RE: Project Brown & Jackson
File # SE-20-00003
Tax Parcel # 295134

I am writing in opposition the proposed project by Brown & Jackson of the placement of two (2) storage septage ponds. The receiving of septage is not a consistent usage of zoned Agriculture 20 land. How did the county come to the conclusion to permit this proposed usage that is clearly not agricultural in purpose or nature? I am disappointed to see this project appears to be being fast tracked through the permitting process. The residents of Kittitas County were given just 2 week to comment to the siting of this potentially devastating project. This is a very short window to complete a well thought out response especially when the county requests 5 weeks to produce additional documentation I requested about the project. However I was able to draft this letter while working 148 hours, farming, and raising 3 kids.

**BROWN & JACKSON**  
 Land Application Site  
 Preliminary  
 Site Map  
 Kittitas County  
 Washington

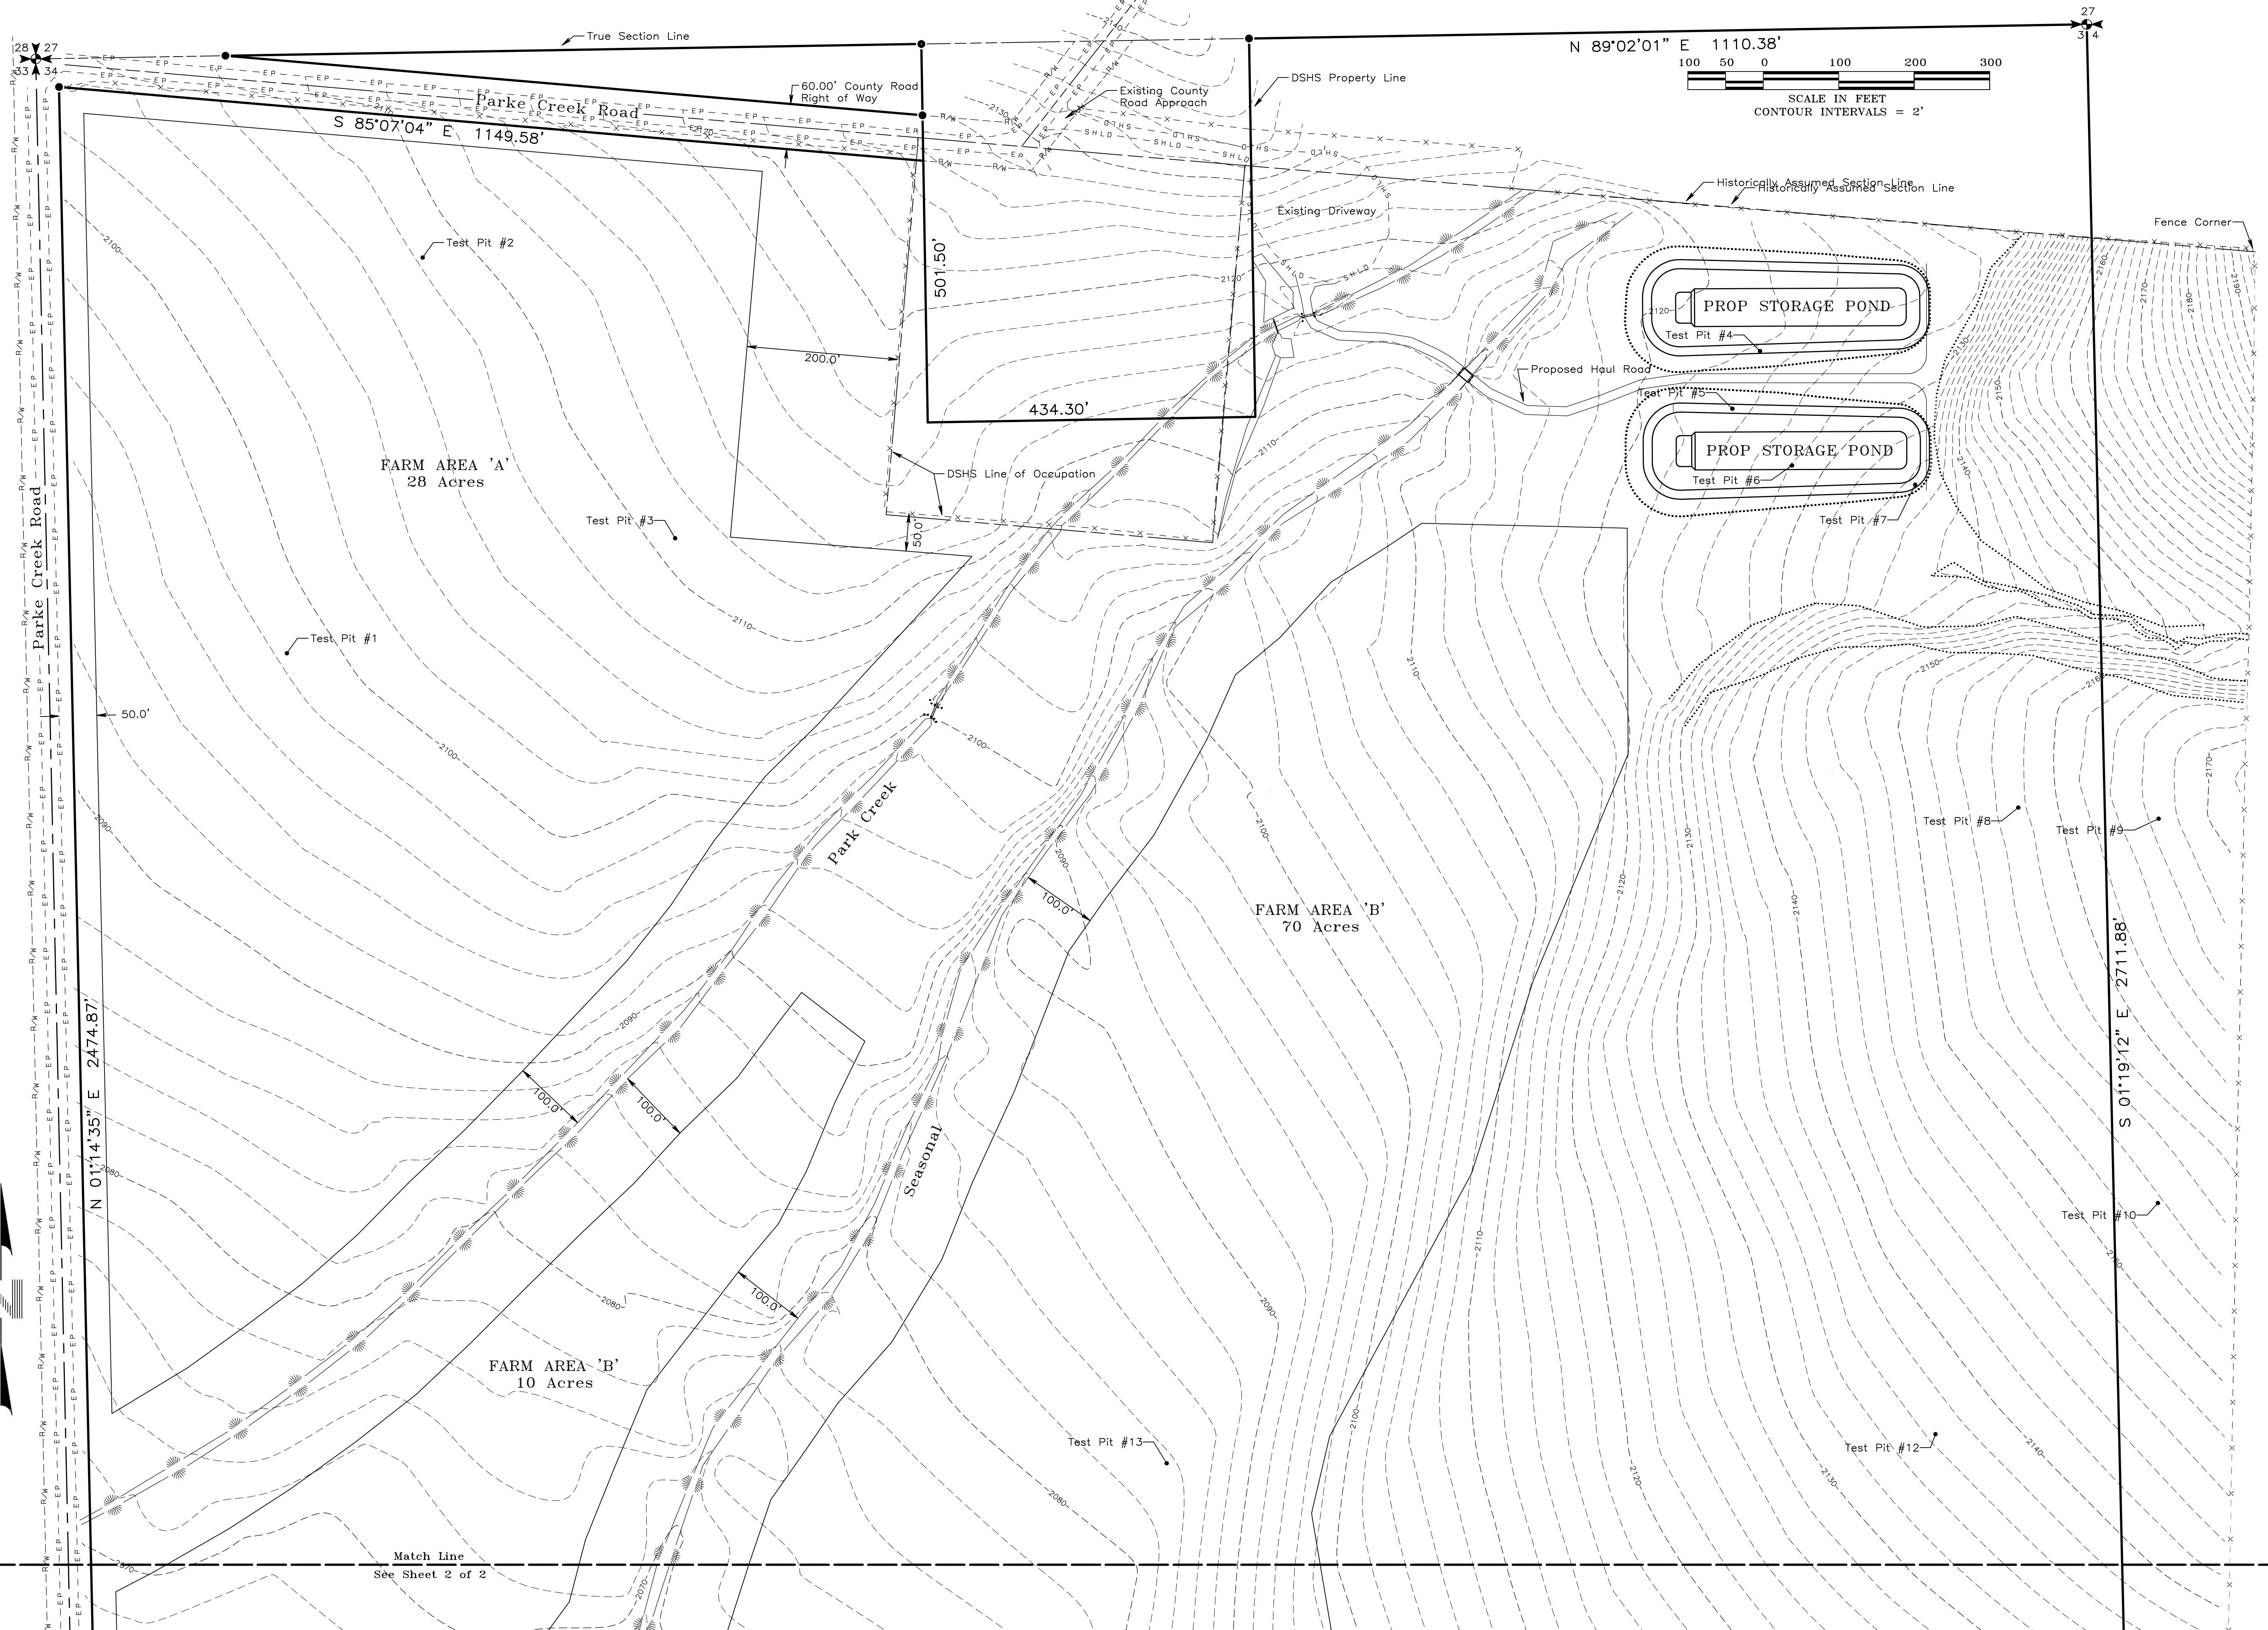
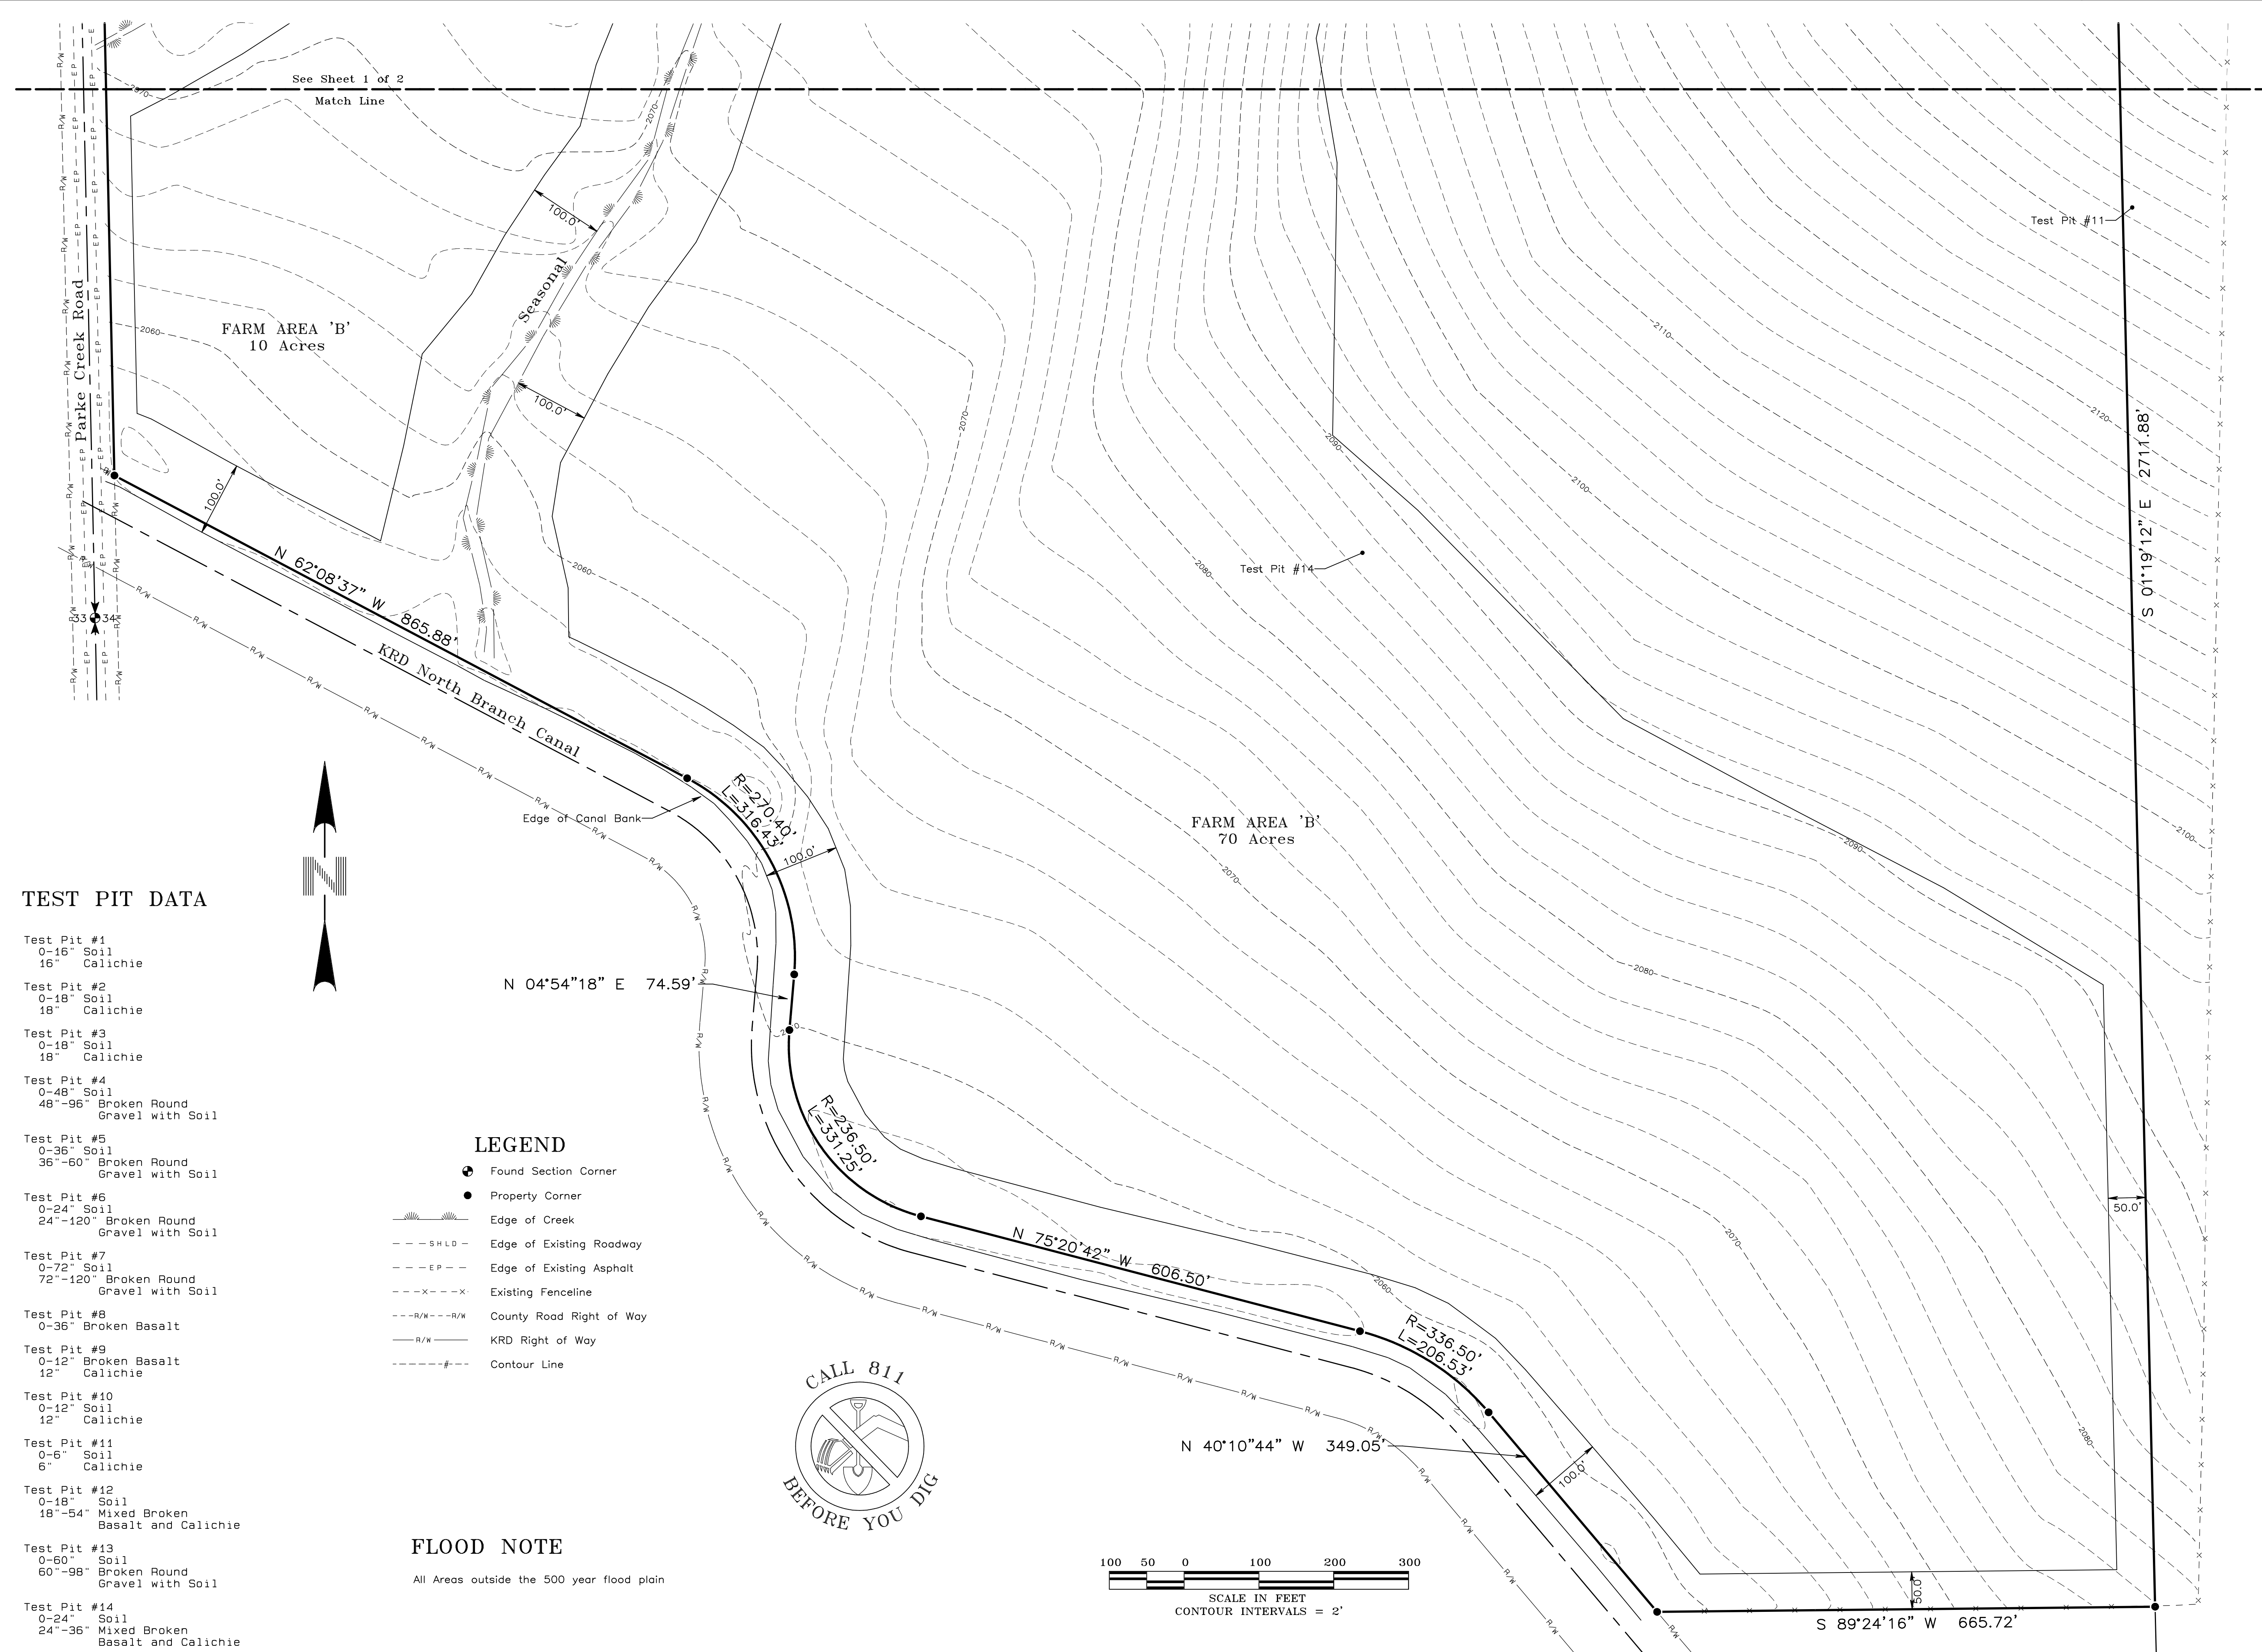
- 6 B.3.a.4) It appears in the drawings provide that surface water runoff will be diverted around the ponds. Has this been looked at how this might affect the flows to surrounding surface waters and possible erosion issues that could come along with the diversions?

- 23 Looking at the drawings provided of the proposed pond locations and application fields it appears they might lie in an area affected by seasonal flooding and run off. With the ponds at the base of a slope and canyon is it a concern of how they will affect run off? It also appears one of the seasonal streams and wetlands are not on the provide drawings.
